RE: Monument Ridge – Retail Paint Store Final PUD Plan

Your Final PUD Plan for Monument Ridge – Retail Paint Store has been reviewed by outside agencies and Town Staff. Comments and necessary revisions have been compiled and are provided below. Some items are summarized in the interest of being concise and clear. Names and contact information are provided should you need to discuss any of the comments with the specific reviewer. Town comments are provided at the end of the letter; duplicate comments have been removed for your convenience. There may be additional comments/revisions as a result of your response to this first round of comments. We are happy to discuss any of these items, if necessary.

# 705 W. BAPTIST RD. PRELIMINARY SITE PLAN

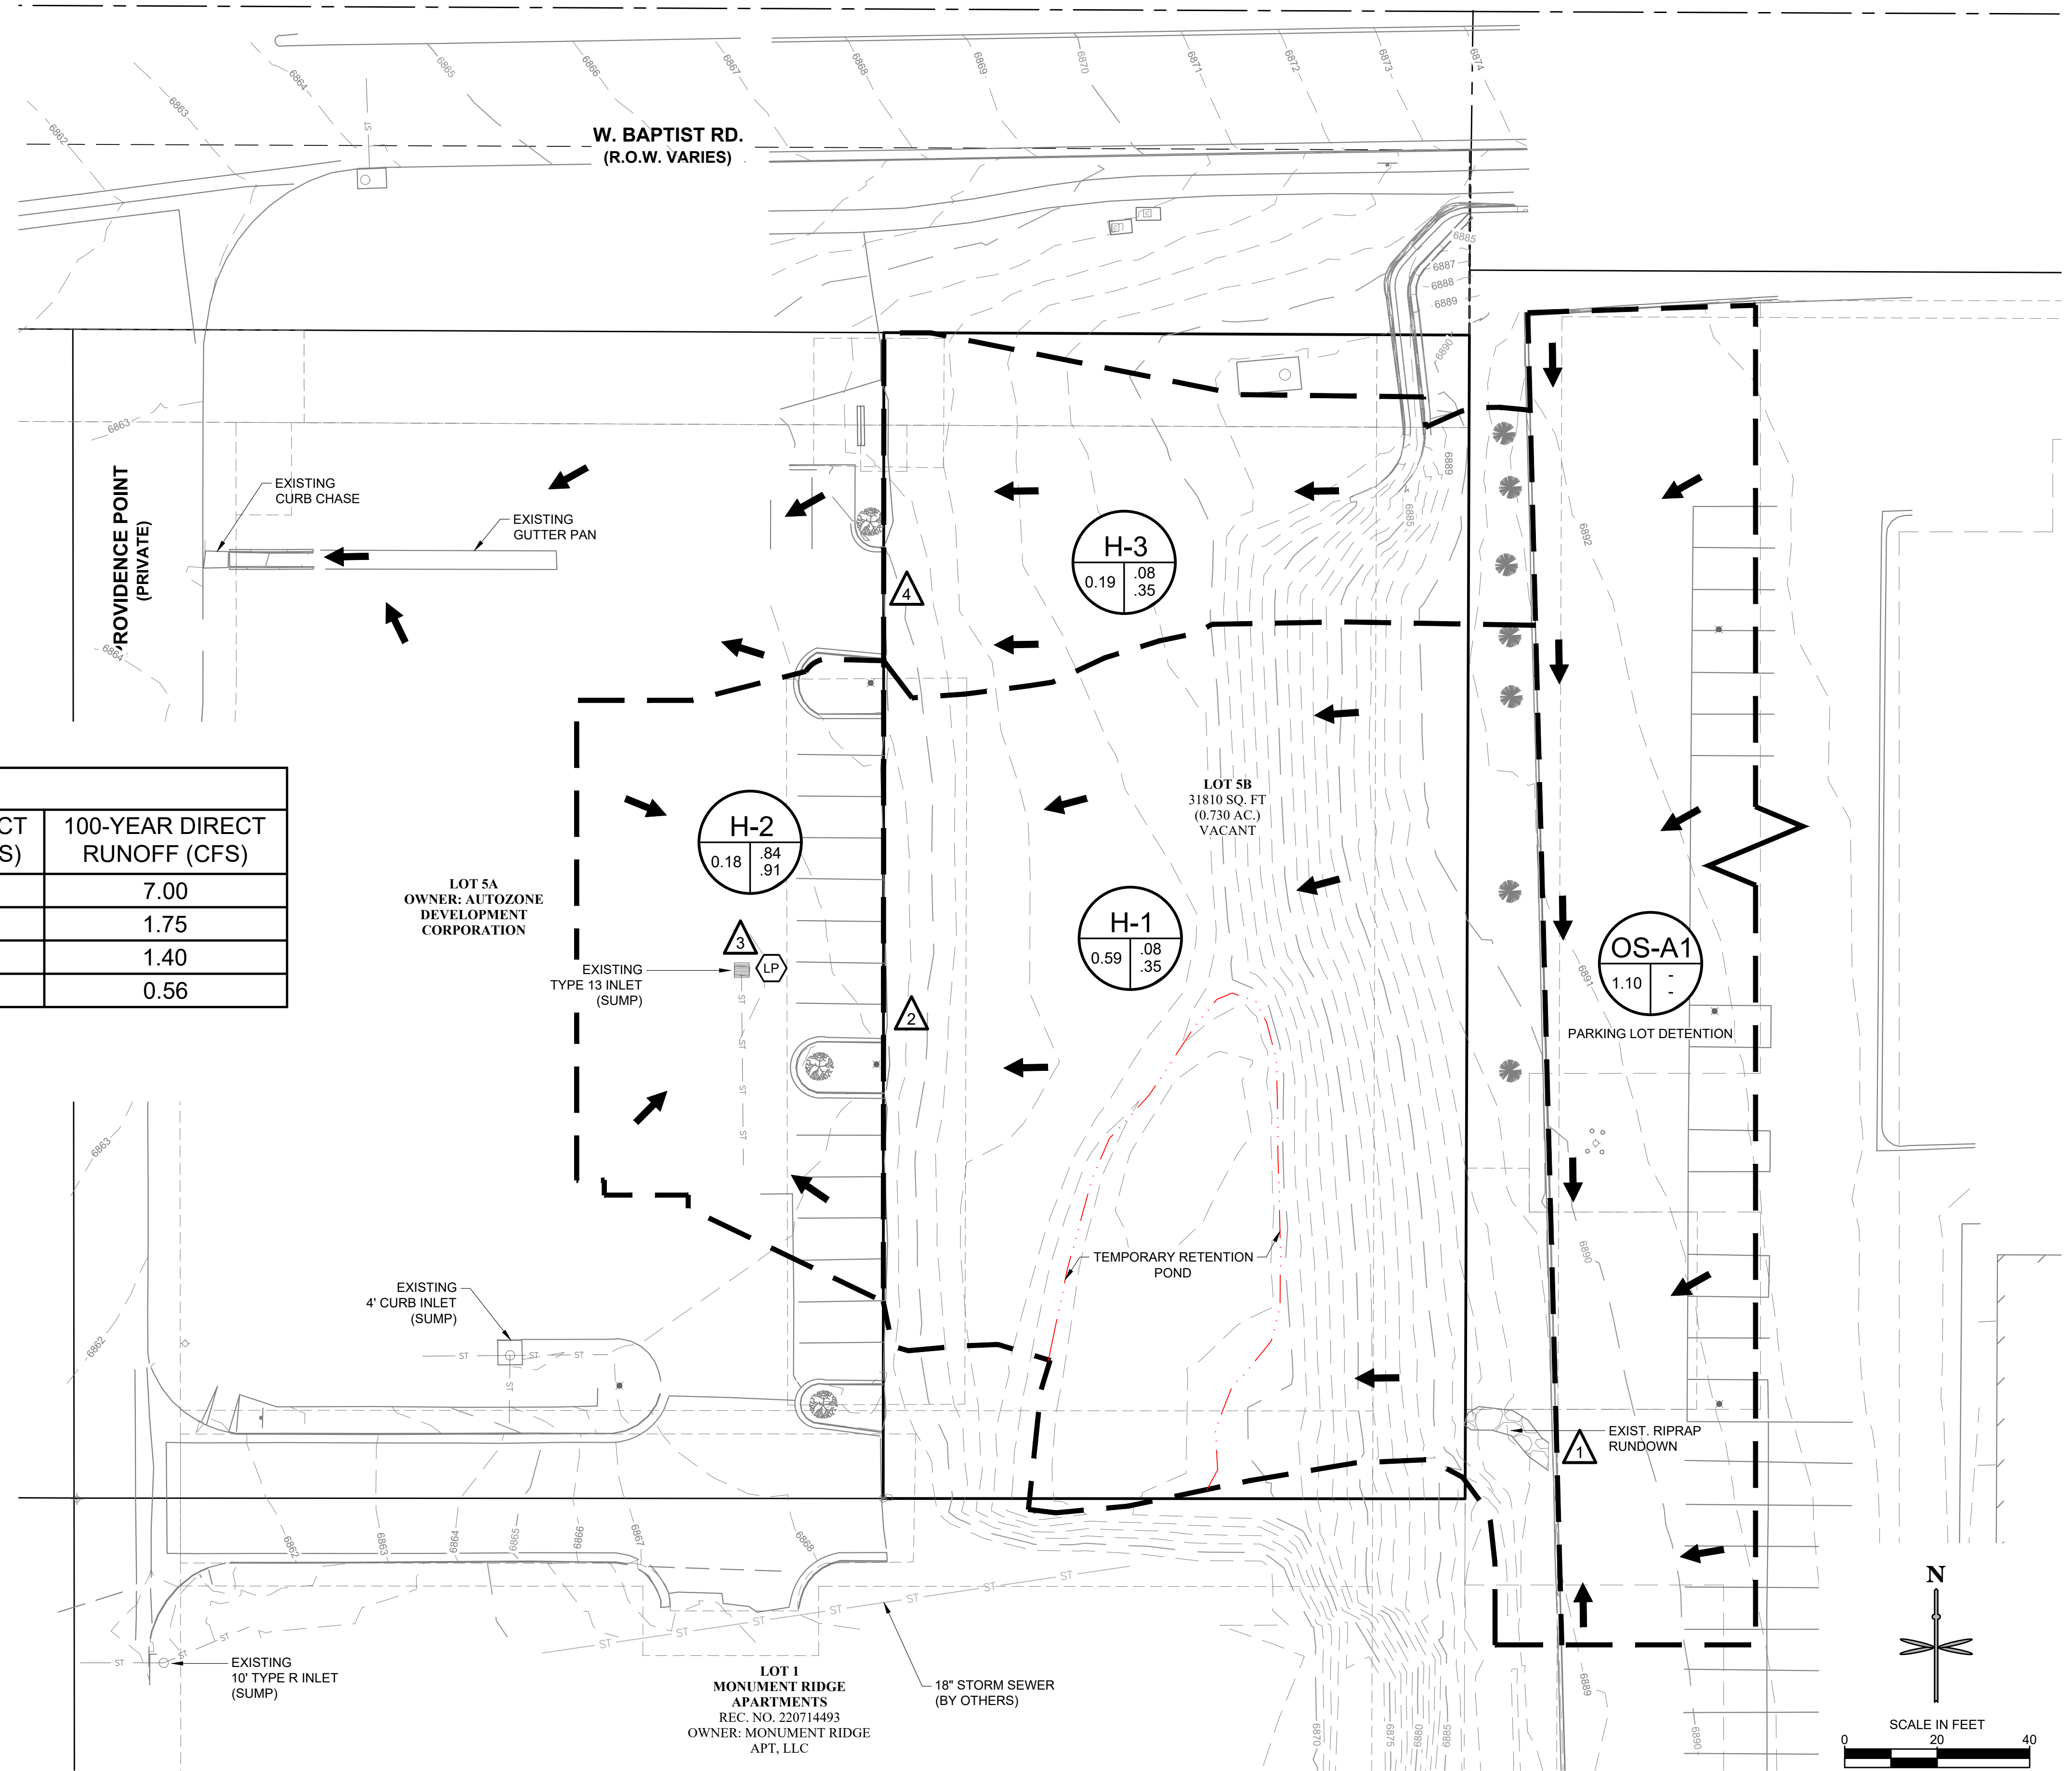
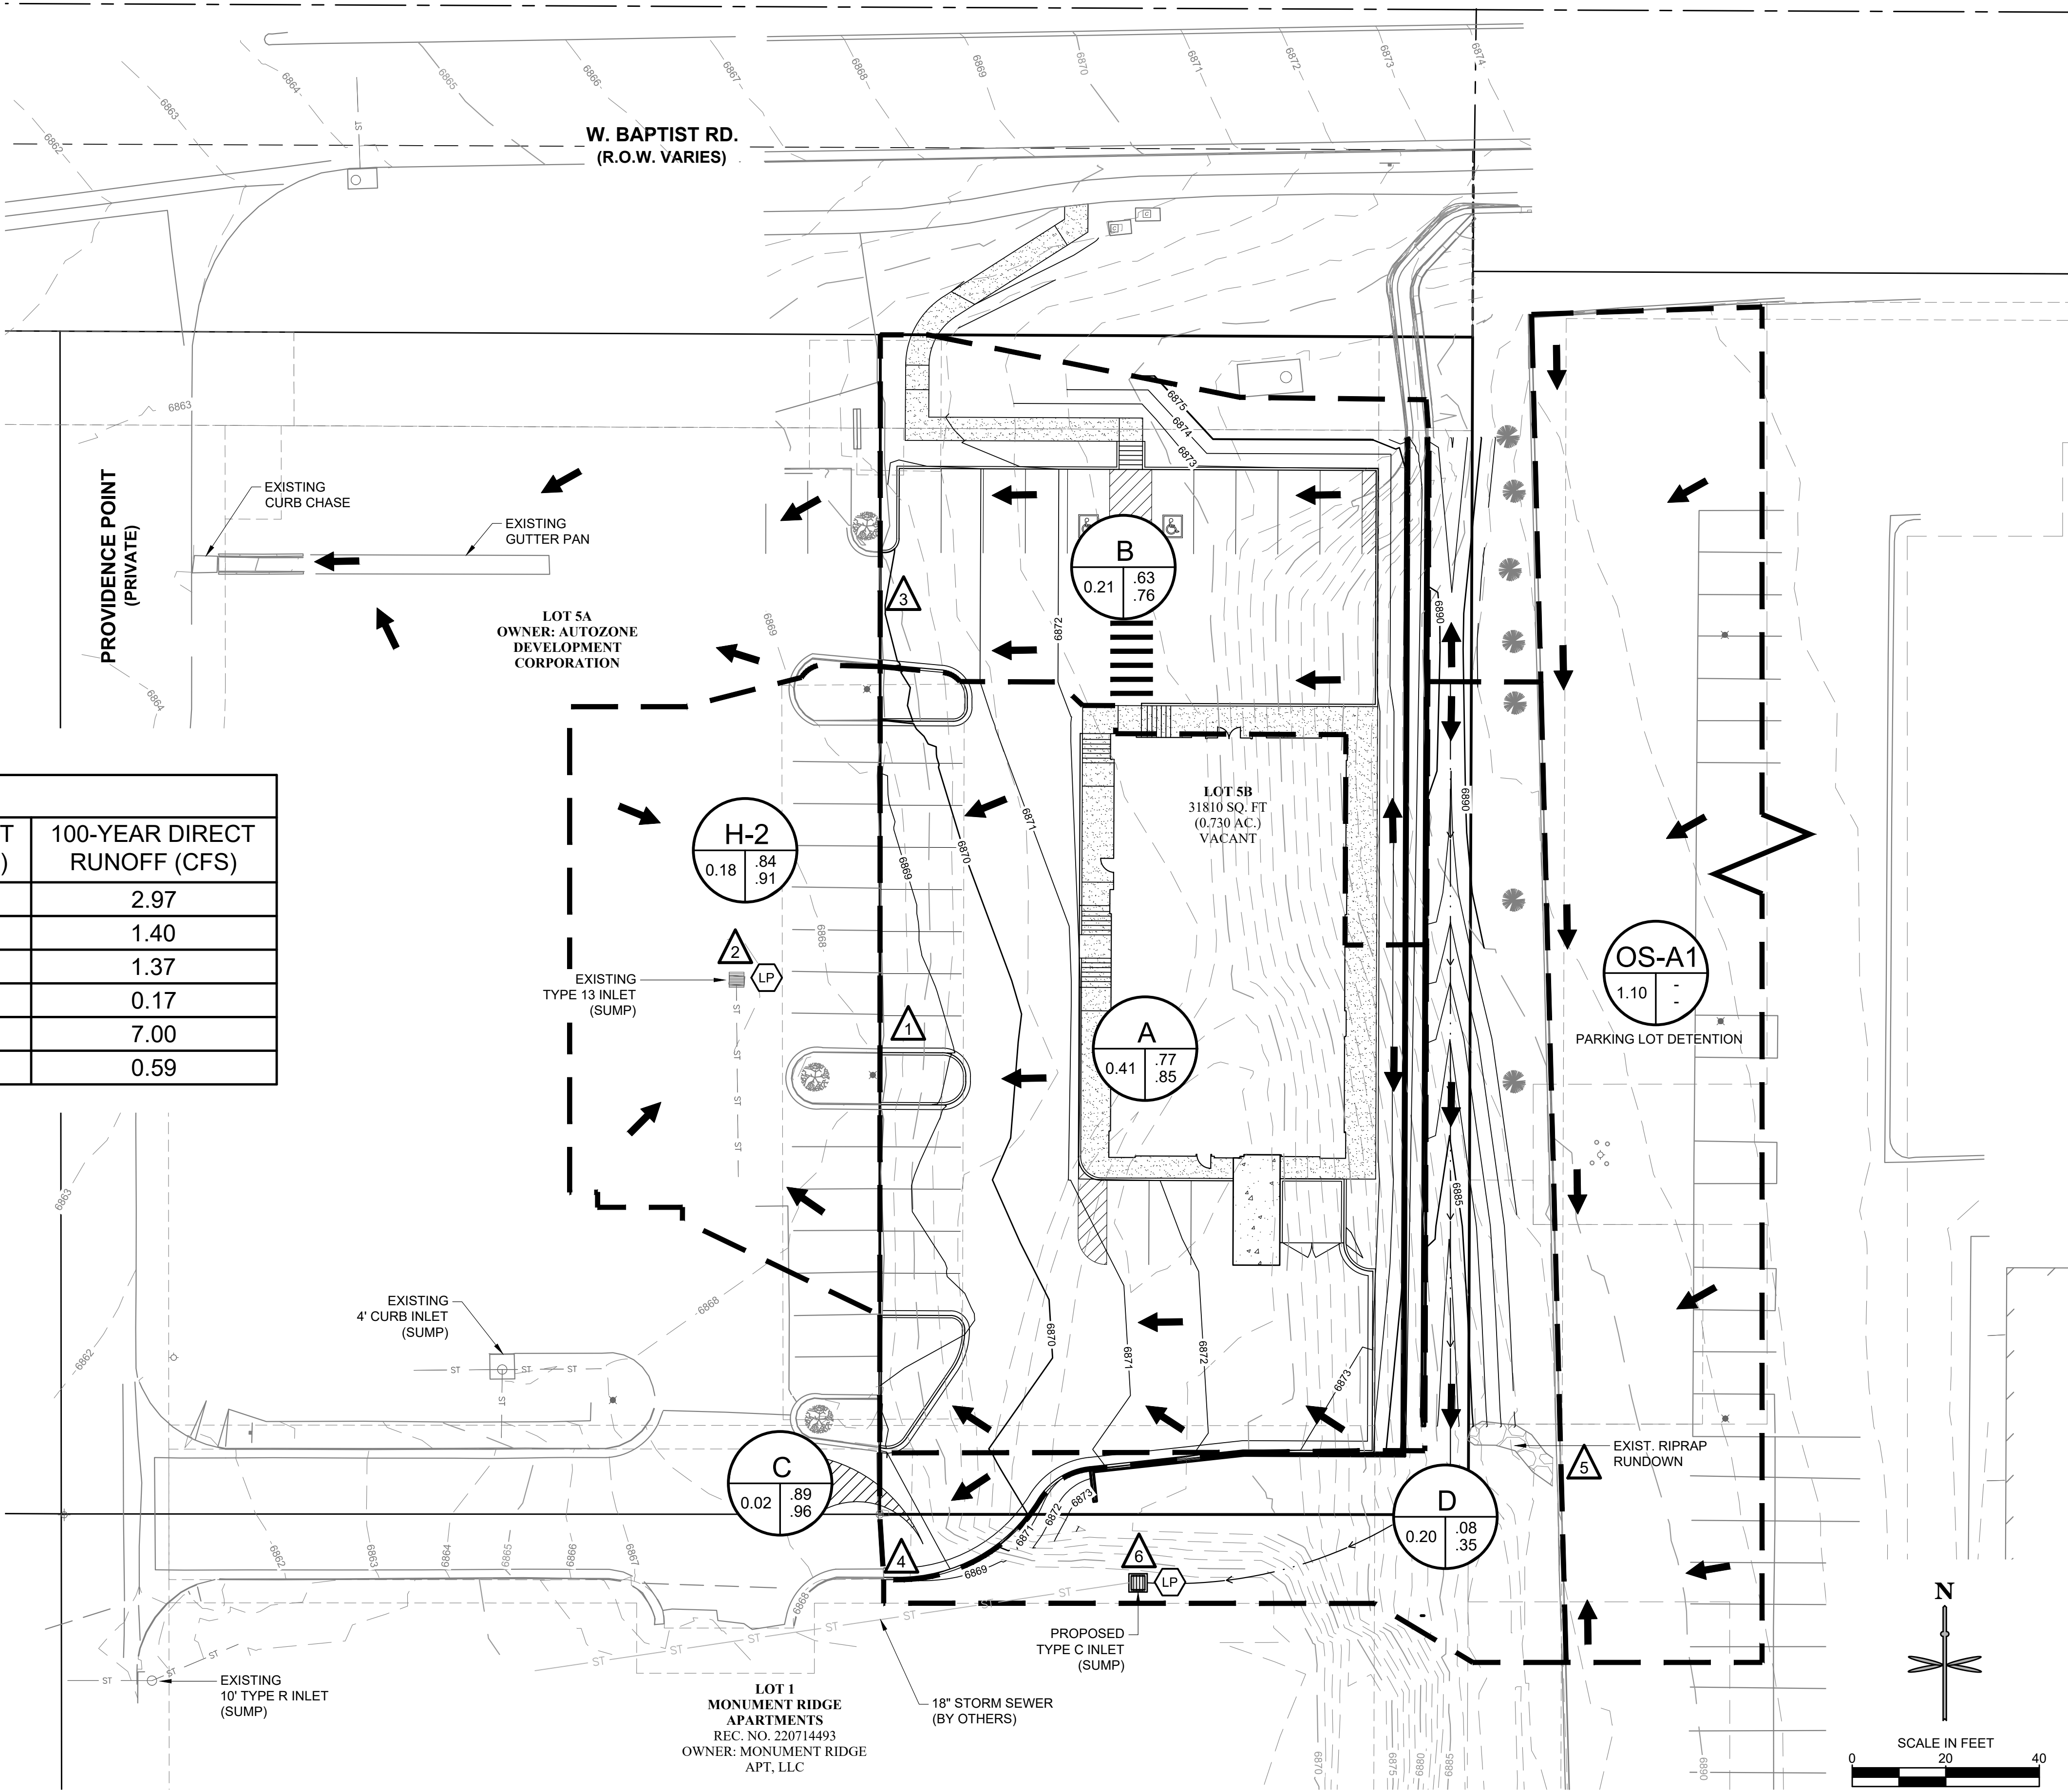
1. There appears to be a typo in the Basin Summary Table, C5 value for Design Point 4 is 0.89 elsewhere in the report.

2. An easement may be required for the off-site diversion ditch and Type C inlet, as well as the storm pipe from the Type C inlet. Operation and maintenance responsibilities need to be addressed.

3. Autozone and Monument Ridge Apartments plans indicate provisions for a 24” storm pipe stub, originating in the Lot 1 Monument Ridge Apartments tract, due south of the curb inlet on the Autozone site. This current plan indicates an 18” pipe extending from this general vicinity, and indicates the pipe is “by others.” As stated previously, it is not clear whether this pipe exists or is proposed, and if the latter, who will install and maintain it.

EES Response: Per the rational calculations this value should be 0.89. Where 0.90 was called-out it was incorrect and is now revised.

EES Response: Type C inlet no longer proposed here.

EES Response: Please see previous discussion.
